## Appeal Decisions

### Appeal Ref: APP/C1950/A/08/2067422 (Scheme A) 36 Theobalds Road, Cuffley EN6 4HL

### Appeal Ref: APP/C1950/A/08/2070234 (Scheme B) 36 Theobalds Road, Cuffley EN6 4HL

Project 36 Theobalds Road Cuffley
Drawing Proposed Plans

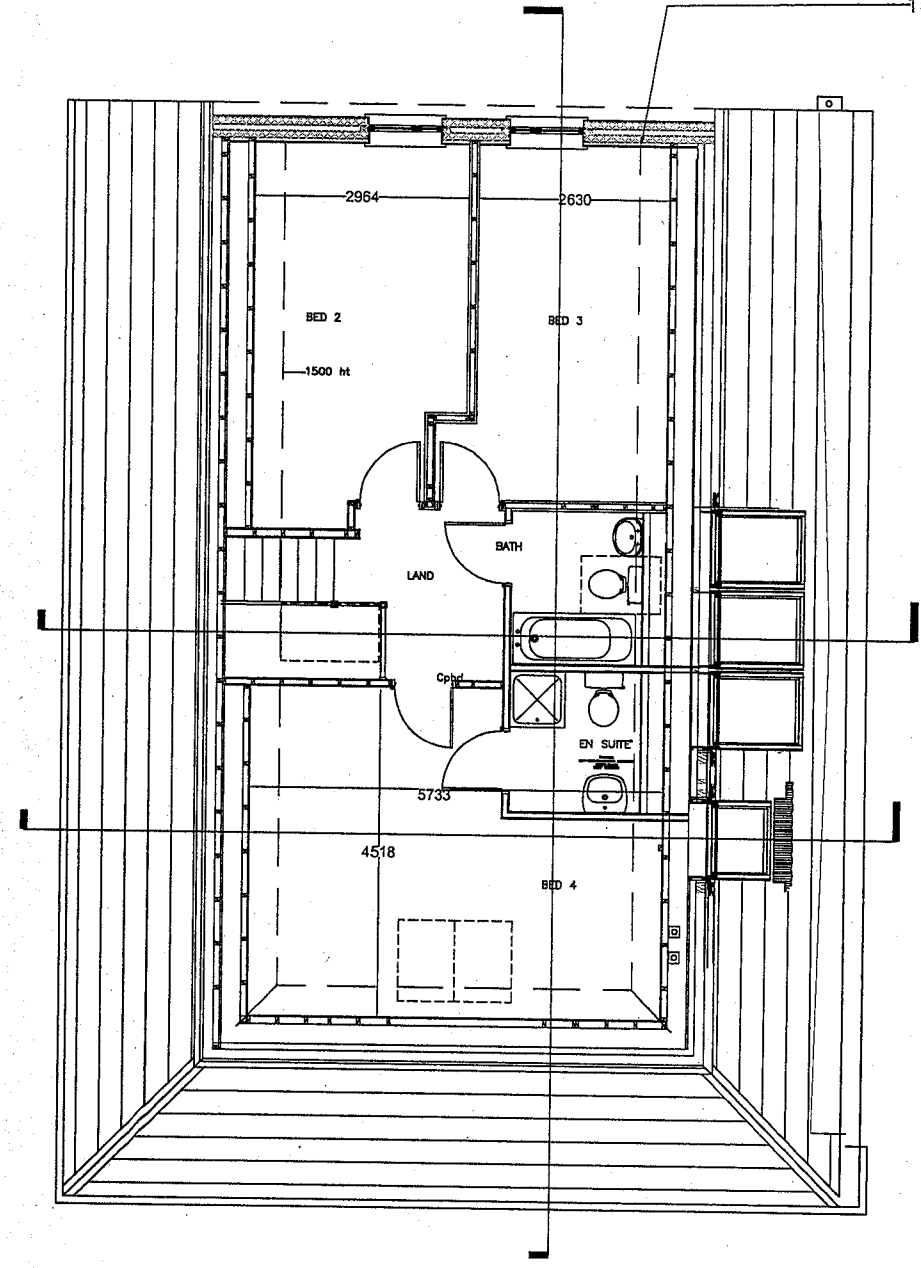
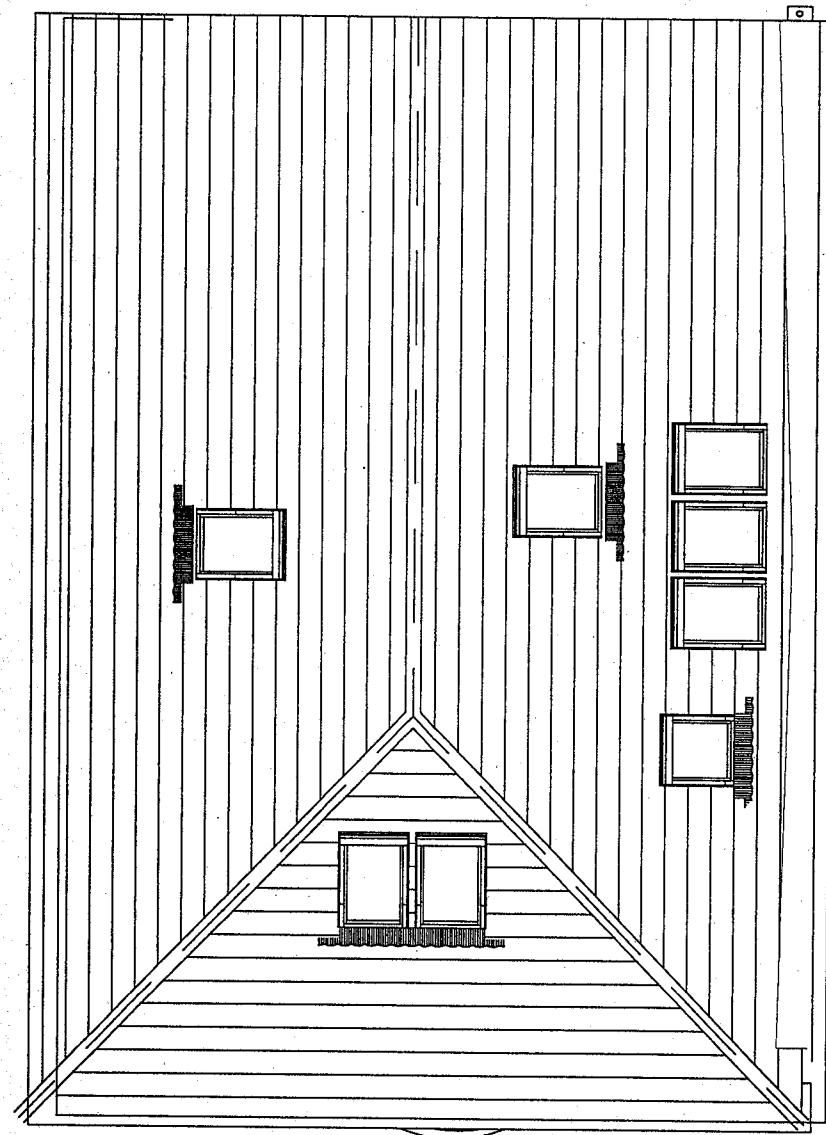
3. The property is a modest bungalow with hipped roof built on simple lines. Both schemes incorporate a side extension measuring 14.6m deep and 2.6m wide. Although built in line with the front and rear elevations of the existing bungalow, the extension in Scheme A would be hard up against the boundary with No 34 to the north. In Scheme B the ridge height would be increased by about 0.8m and the hipped roof at the rear of the property would be re-modelled to a gable end. The depth of the property would not be increased

but in both schemes it would be significantly wider overall with the side extension built up to the boundary with No. 34.

Drawing Proposed elevations

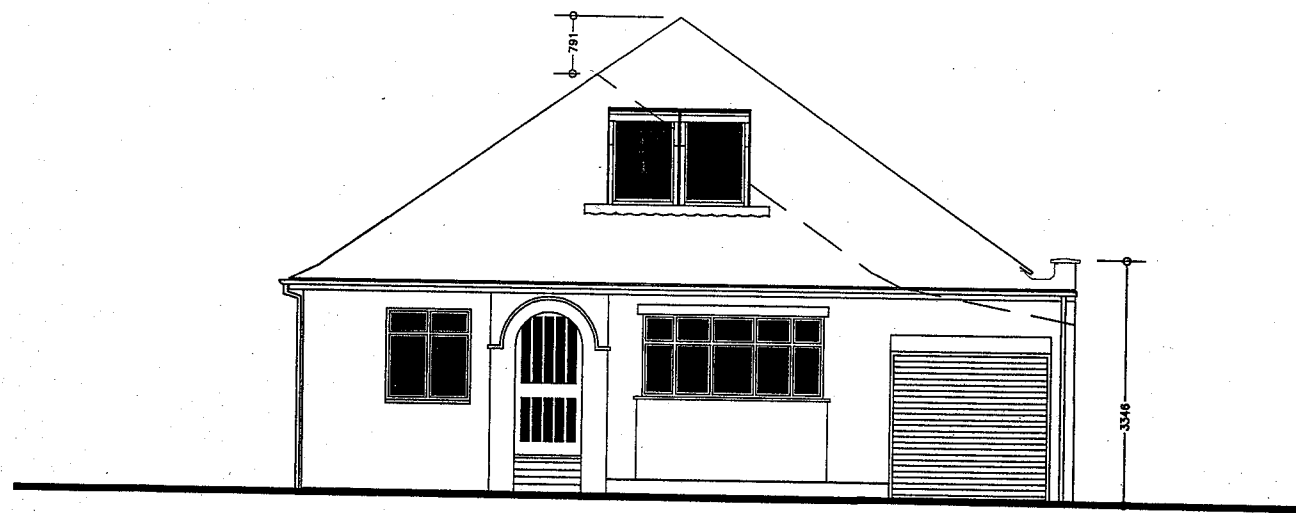
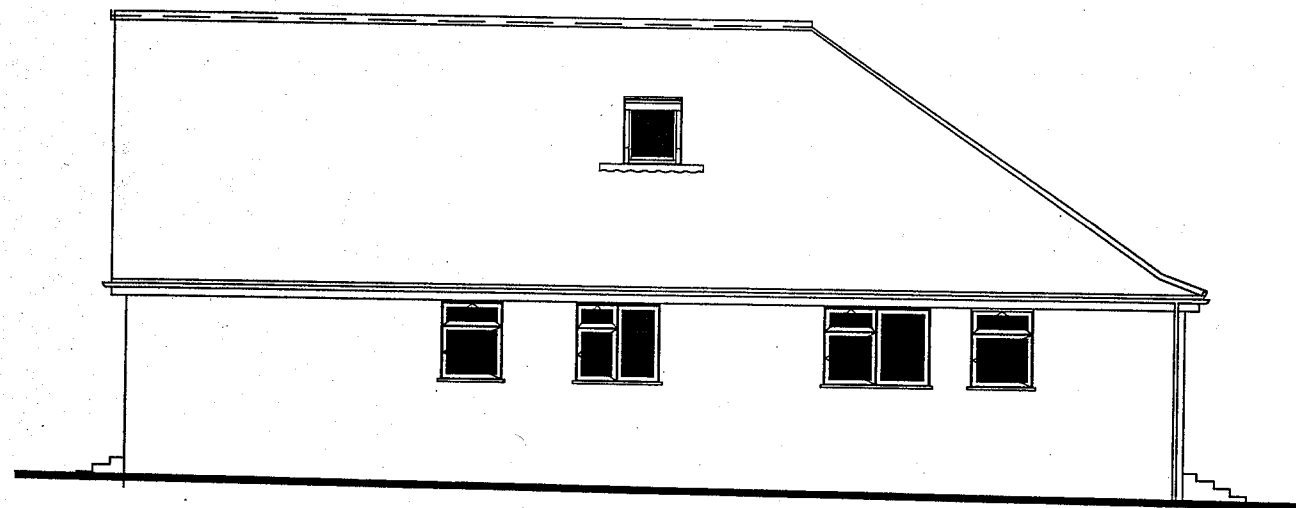
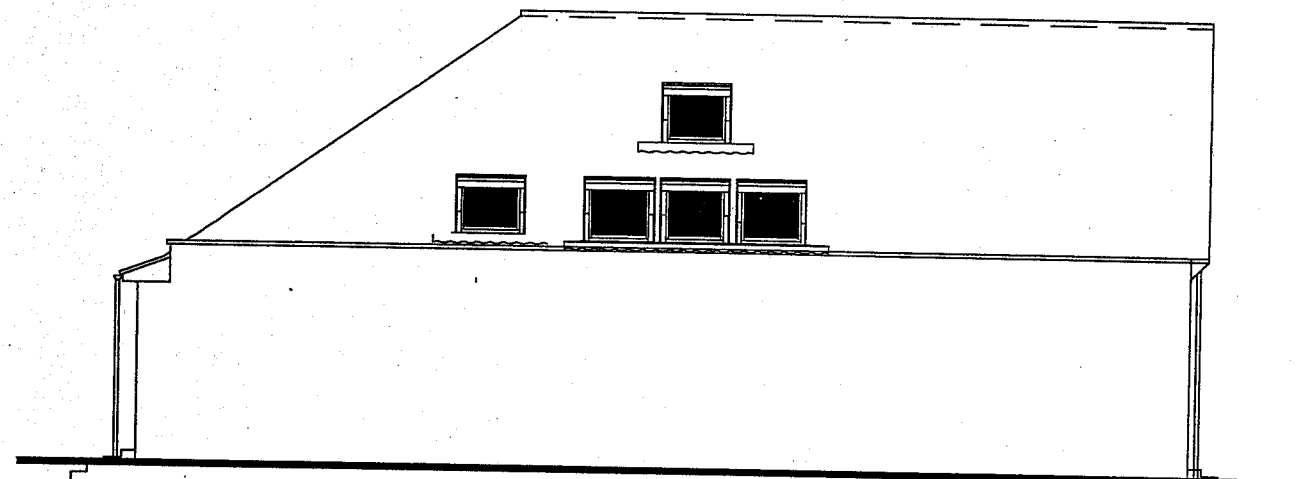
4. In both cases, I judge that the resulting, distinct lack of separation between the properties would give the extended bungalow a cramped and ungainly appearance. This would be emphasised in the case of Scheme A by the awkwardly re-modelled garage roof with its gable end, at a height of about 4.5m, on the boundary. The appellants suggest that the design of the roof reflects that of a previous approval. However, I have no detailed information before me in relation to this and therefore give it little weight.

6. Similar general considerations would apply to the substantially enlarged roof in Scheme B. Even allowing for the larger footprint I consider that, rather than appearing subservient, the proposed extensions would both physically and visually overwhelm the original modest bungalow.

11. A covered walkway, designed to let light through, is provided along the southern side elevation of No. 34. I saw that, aided by the separation between the properties and the set back position of No 36's garage, the ambient light level within the access passage was fairly good, albeit on a sunny day. However, in both schemes the proposed side extension to No. 36 would be built right up to the boundary with No. 34, at a maximum height of about 4.5m.

12. In both cases I judge that the introduction of such an imposing structure at such close range would overshadow the side aspect of No.34, so unacceptably reducing the ambient light to the passageway and the daylight available to the south-facing windows, particularly those serving the kitchen and dining room. In both cases, therefore, I conclude that the extension to No. 36 would spoil the residential neighbours' reasonable enjoyment of their property, contrary to the good design principles required by Policy D1 of the Welwyn Hatfield District Plan.
